**KIRKLEES METROPOLITAN COUNCIL
INVESTMENT & REGENERATION SERVICE**

**DELEGATED DECISION TO DETERMINE APPLICATIONS FOR
CONSENT, AGREEMENT OR APPROVAL REQUIRED BY CONDITION**

Reference No: 2020/44/90823/W

Description: Discharge condition 6 (drainage) on previous permission 2016/91502 for outline application for erection of one detached dwelling

DRAWING DESCRIPTION			
PROPOSED BUILDING REGULATIONS			
JOB TITLE			
CORNER VIEW HOUSE			
LIPHILL BANK ROAD			
CLIENT			
MR & MRS CRUICKSHANK			
DRAWN BY			
SCALE 1:50 @ A1			
DATE MAY 2018	DRAWING NO. 138/2-004		REVISION B
CHECKED

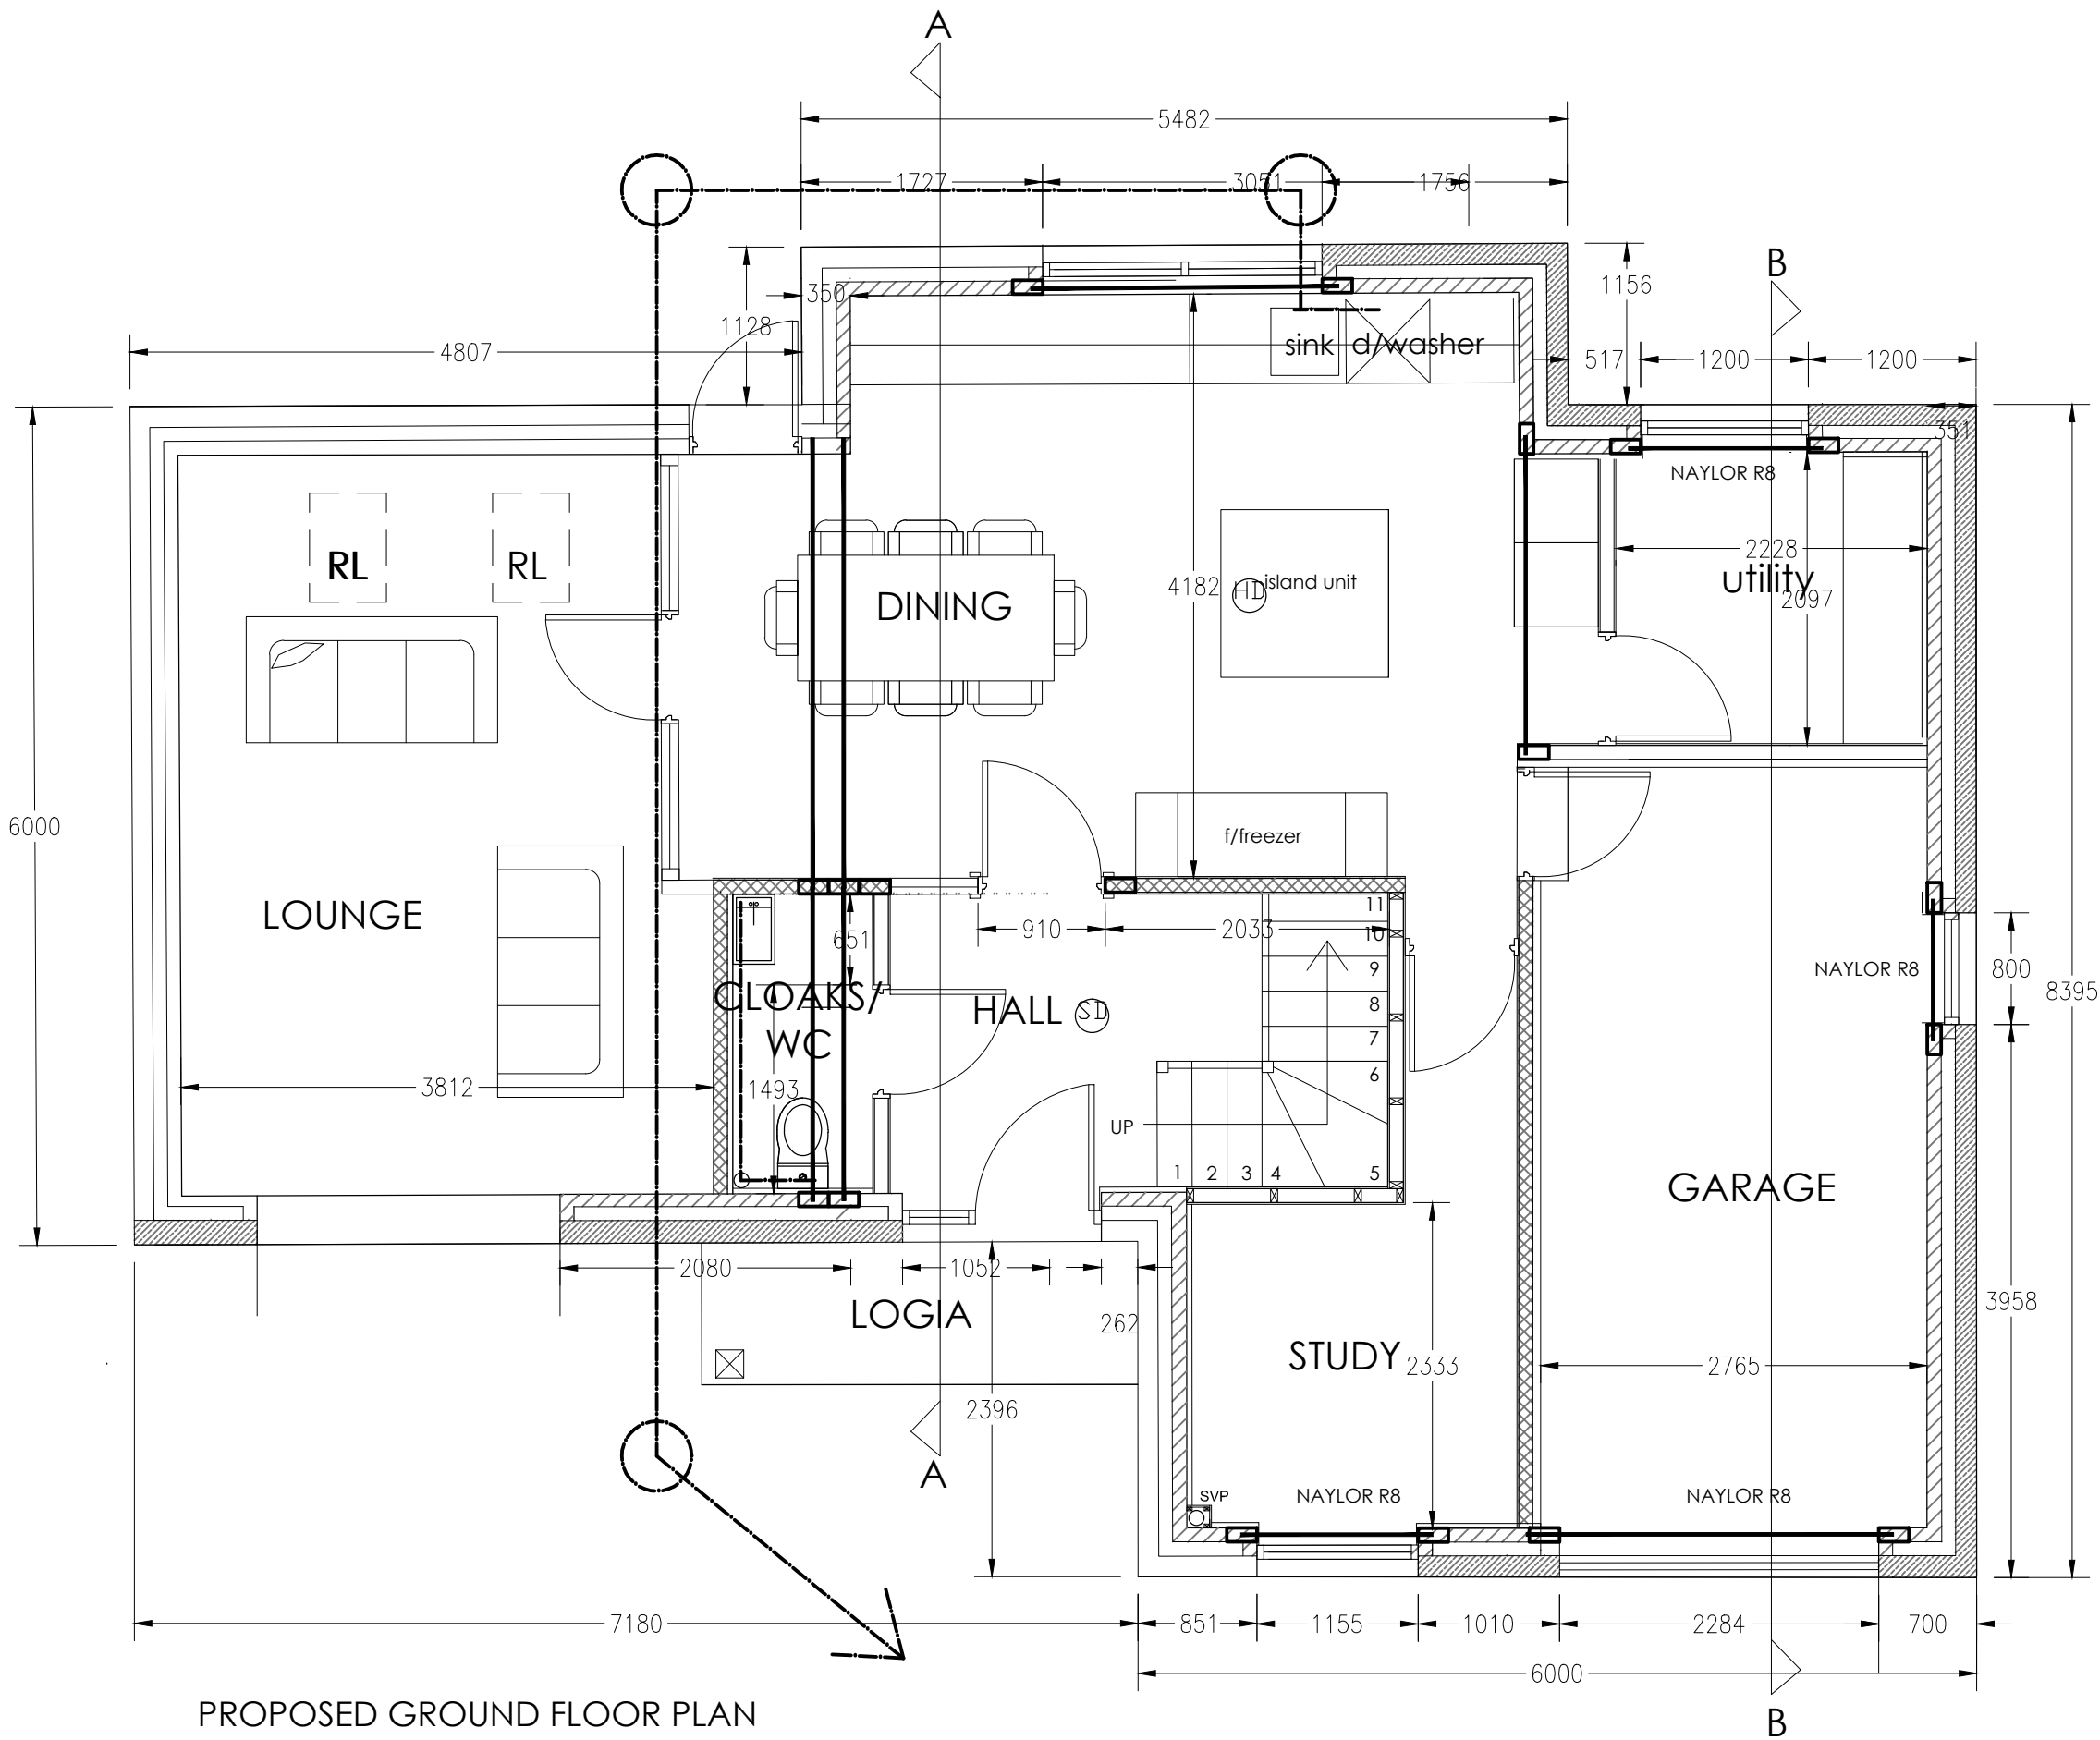
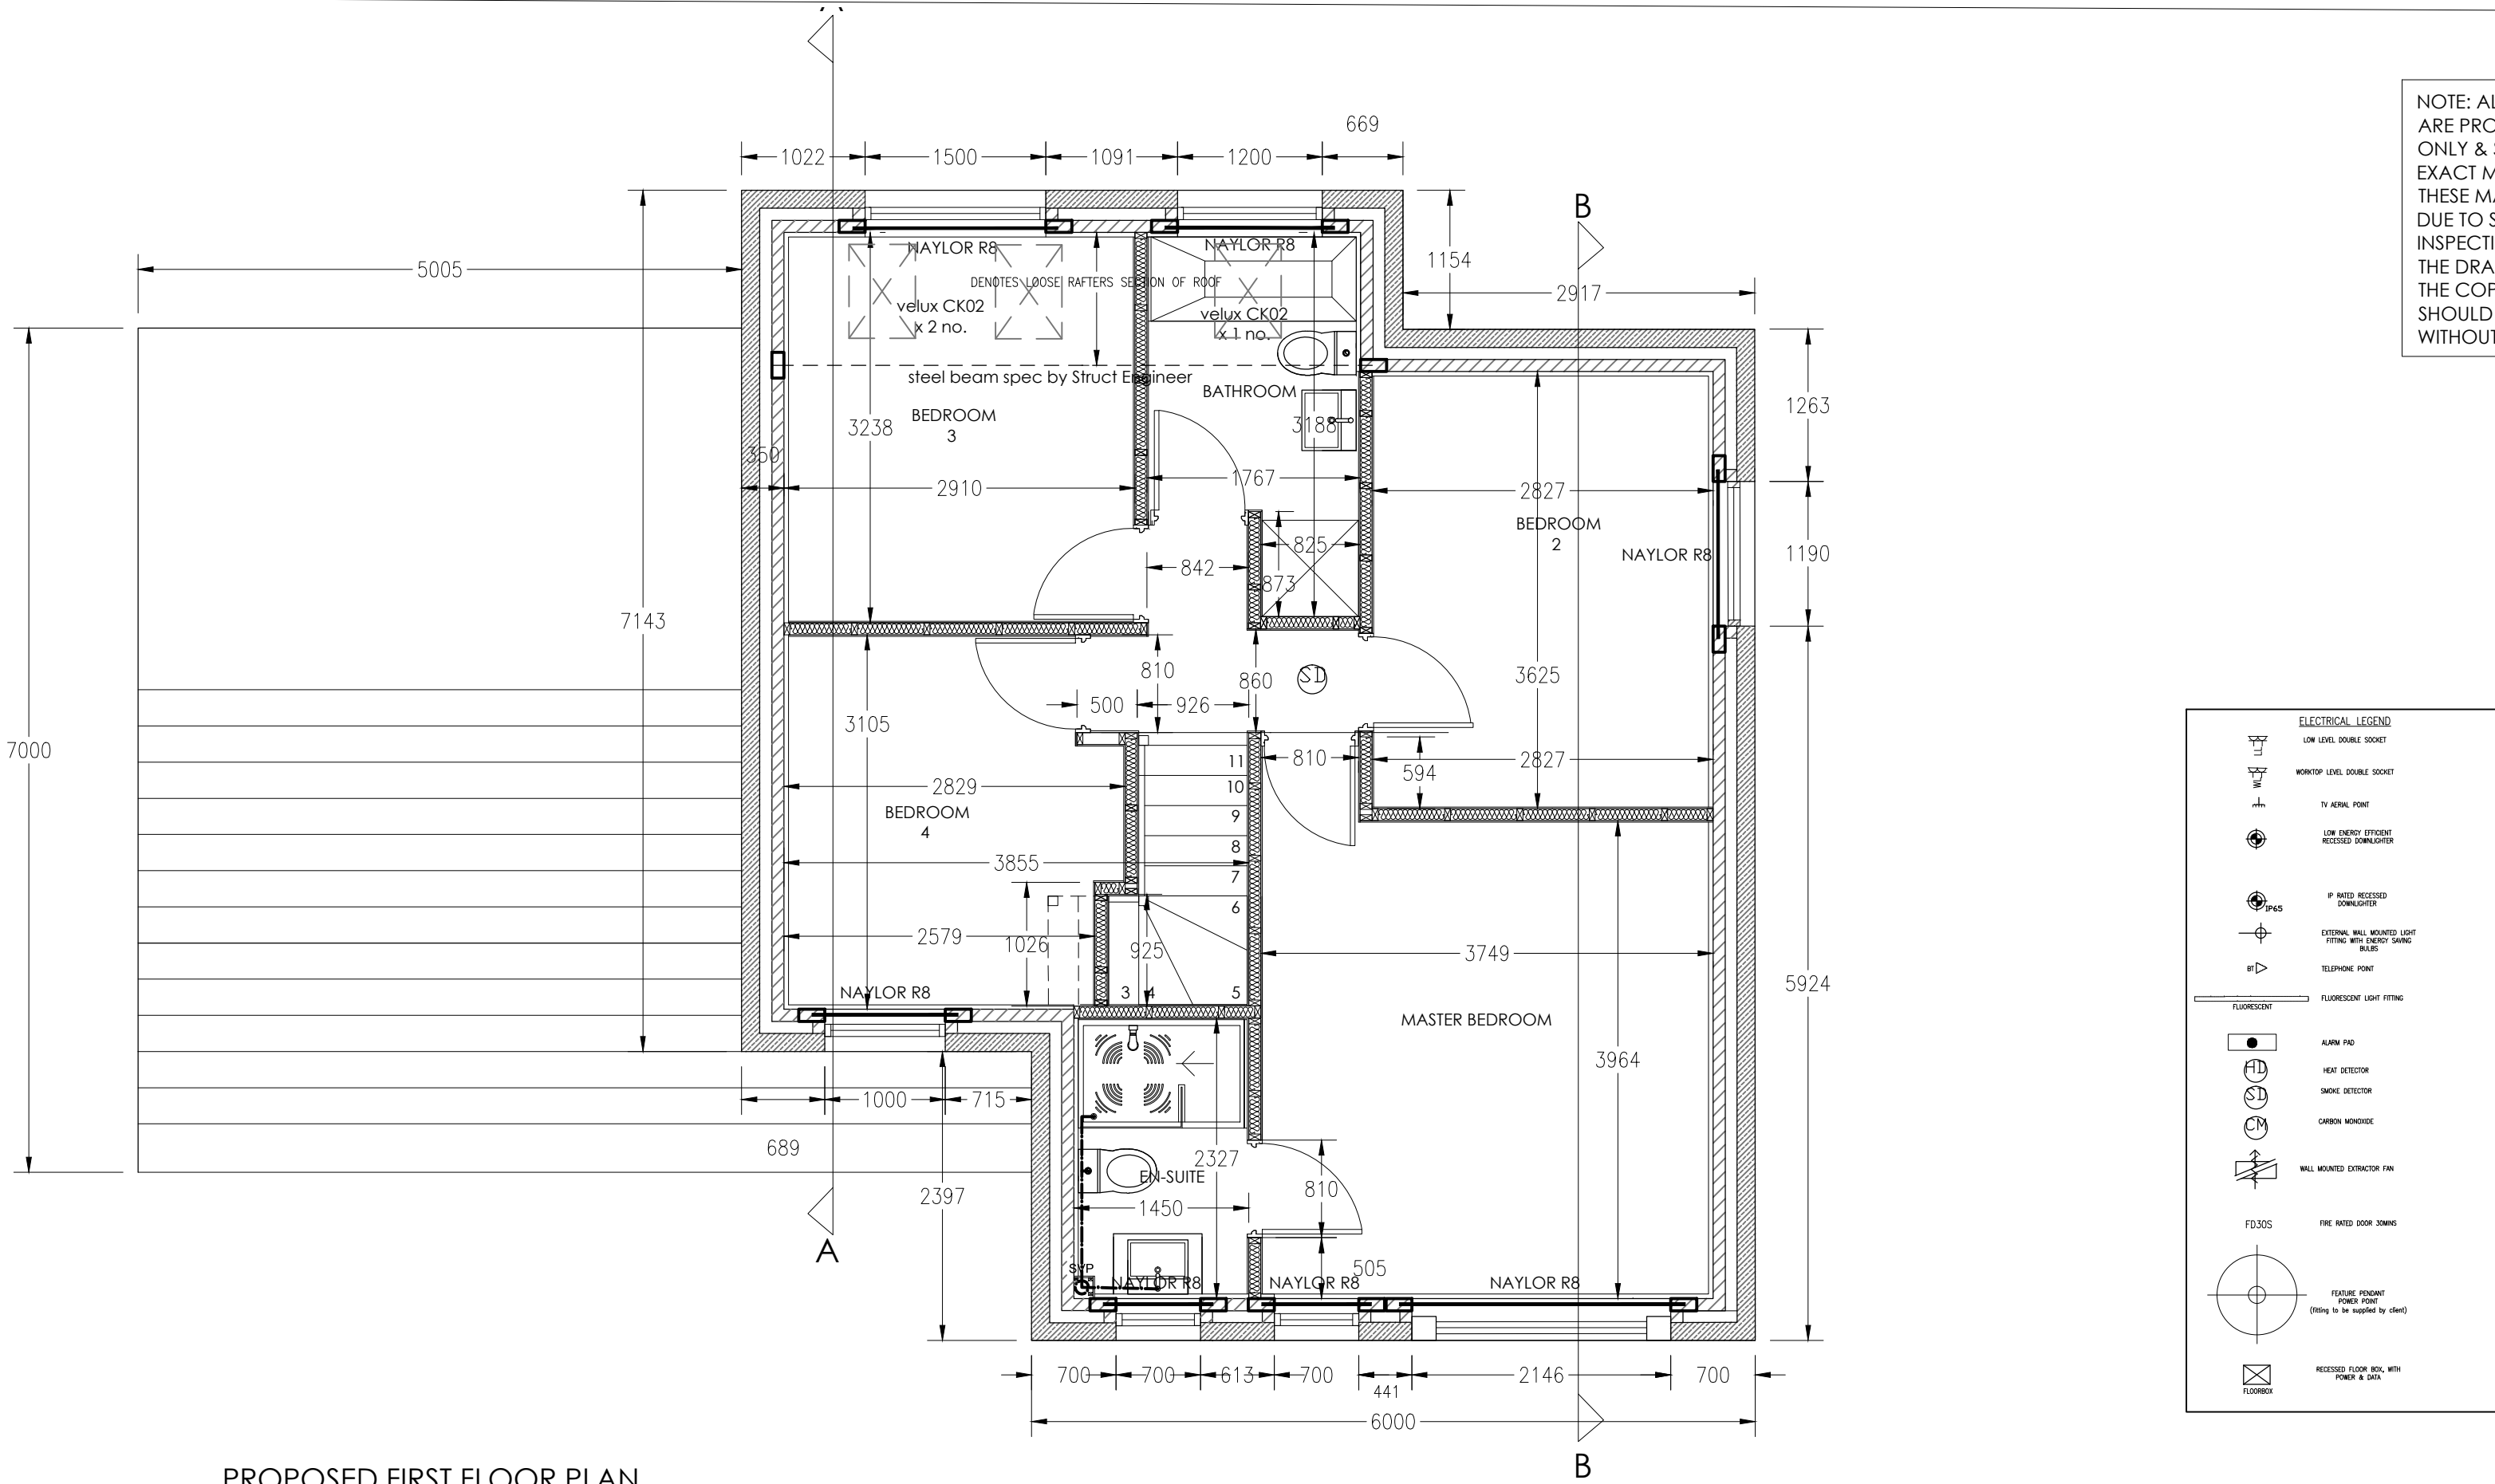
Foul drainage is to be to via Yorkshire Water's combined sewer. This is acceptable given the site's proximity to the network. Such a connection will require permission from Yorkshire Water however officers see no prohibitive reason why this would not be permitted.

Surface water is to be via a percolation tested soakaway. This includes the rain water pipes connecting into the soakaway. Land drainage, with the addition of the soakaway, is to be as existing, excepting the surfaced areas for car parking: this is required by condition 7 to comply with '*the Communities and Local Government; and Environment Agency's 'Guidance on the permeable surfacing of front gardens (parking areas)'*'. It is stated that the surfaced areas will also connect into the soakaway(s), which would comply with the document.

Given the scale and nature of the proposal, the Lead Local Flood Authority are satisfied that the site's drainage will be addressed by Building Regulations. Notwithstanding being a pre-commencement condition, the application is retrospective and Building Regulations have been applied for. Regulation Approved Document H relates to drainage and waste disposal. The applicant has shown the building's competition certificate (ref. 2018/01293) issued by K.C. Building Control. This demonstrates that the drainage has been undertaken in accordance with Building Regulations and is accepted by planning officers.

You have submitted the plan ref. '138 / 2 - 004 Rev. B' as well as the building's completion certificate to discharge condition 6.

I can confirm that the submitted details are acceptable for the purposes of condition 6. It should be noted that condition 6 requires the approved drainage scheme to be provided before the dwelling is occupied and for this approved scheme to be thereafter retained. As such the requirements of the condition cannot be 'discharged'.
